DRB Application No.: 05DRB-01683 (P&F)

Project # 1004529

Project Name: ATLANTIC & PACIFIC ADDN.

RE: Atlantic & Pacific Addition/pp & fp

PLAT OF  
**LOT 24-A**  
**BLOCK "L"**  
**ATLANTIC and PACIFIC ADDITION**  
 WITHIN  
 SECTION 20. TOWNSHIP 10 NORTH, RANGE 3 EAST, N.M.P.M.  
 CITY OF ALBUQUERQUE  
 BERNALILLO COUNTY, NEW MEXICO  
 OCTOBER, 2005

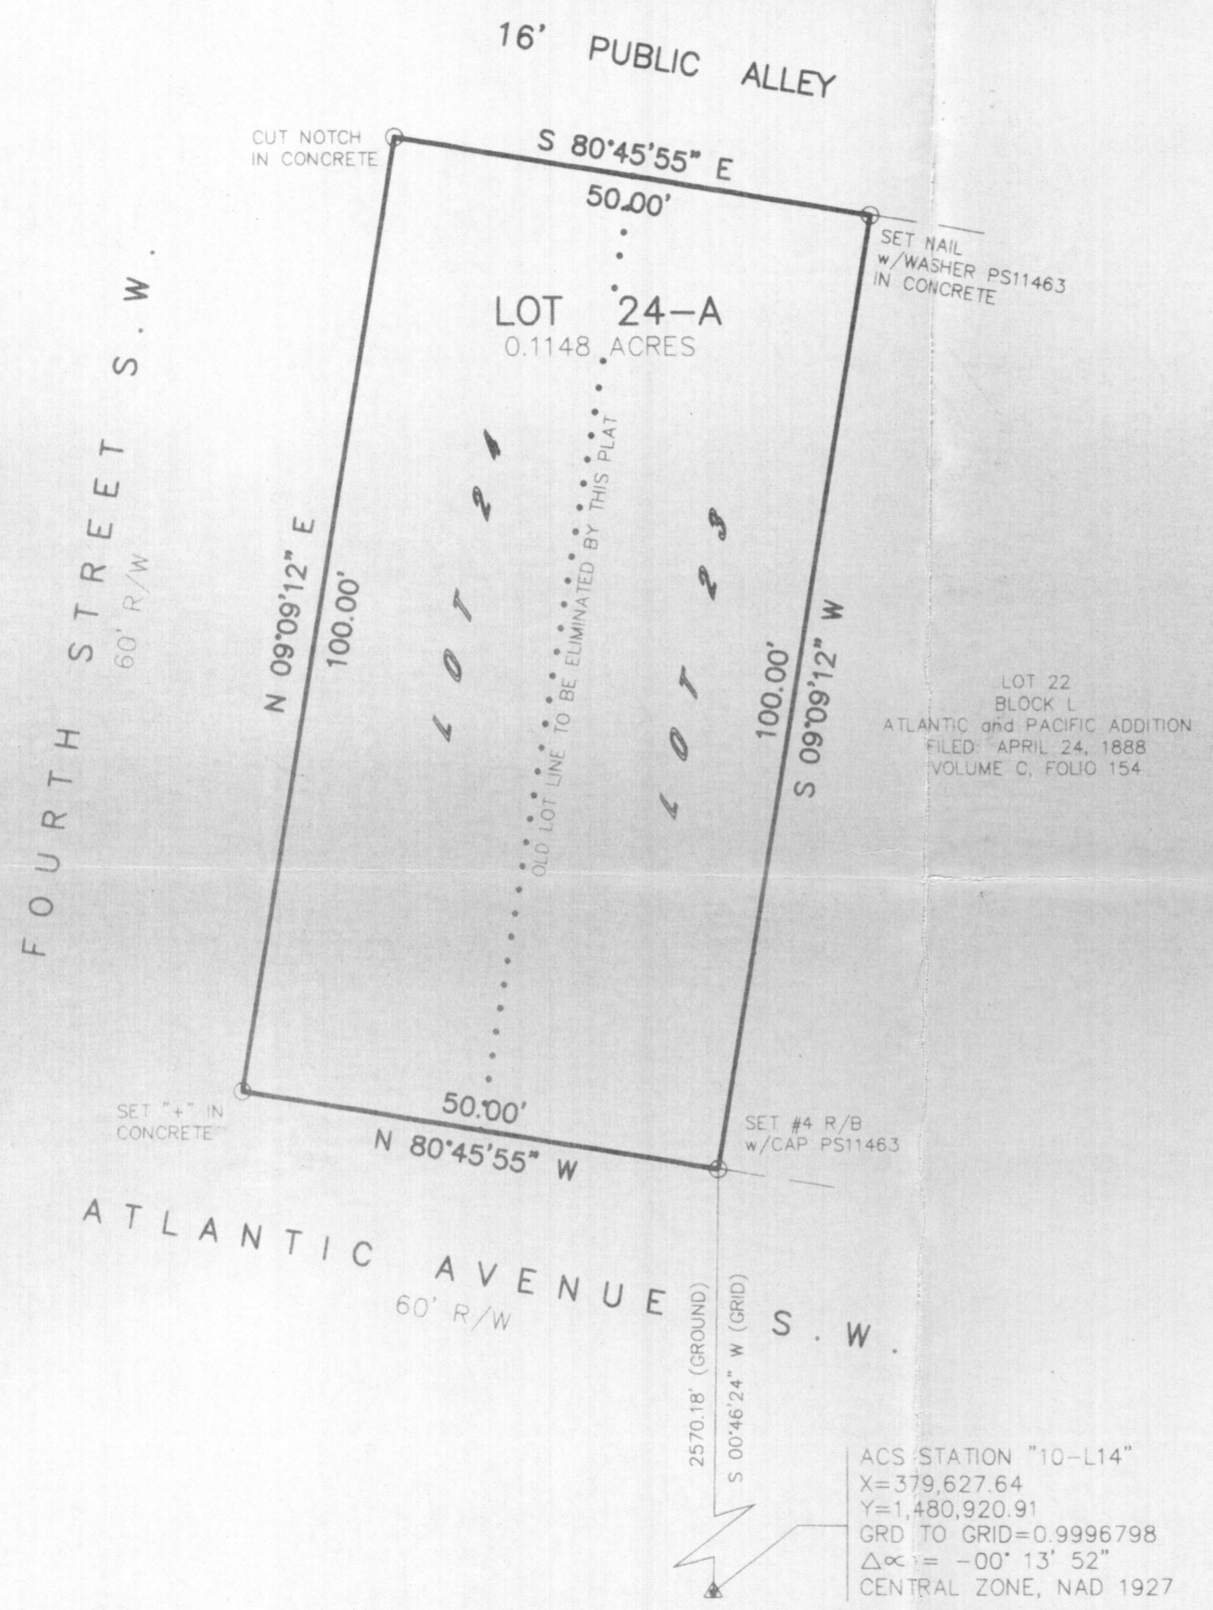
TRANSPORTATION: 2' dedication along the alley

The current zoning designation (R-D) on the application does not match the Plat (R-1). The correct zoning designation should be SU-2/NCR.
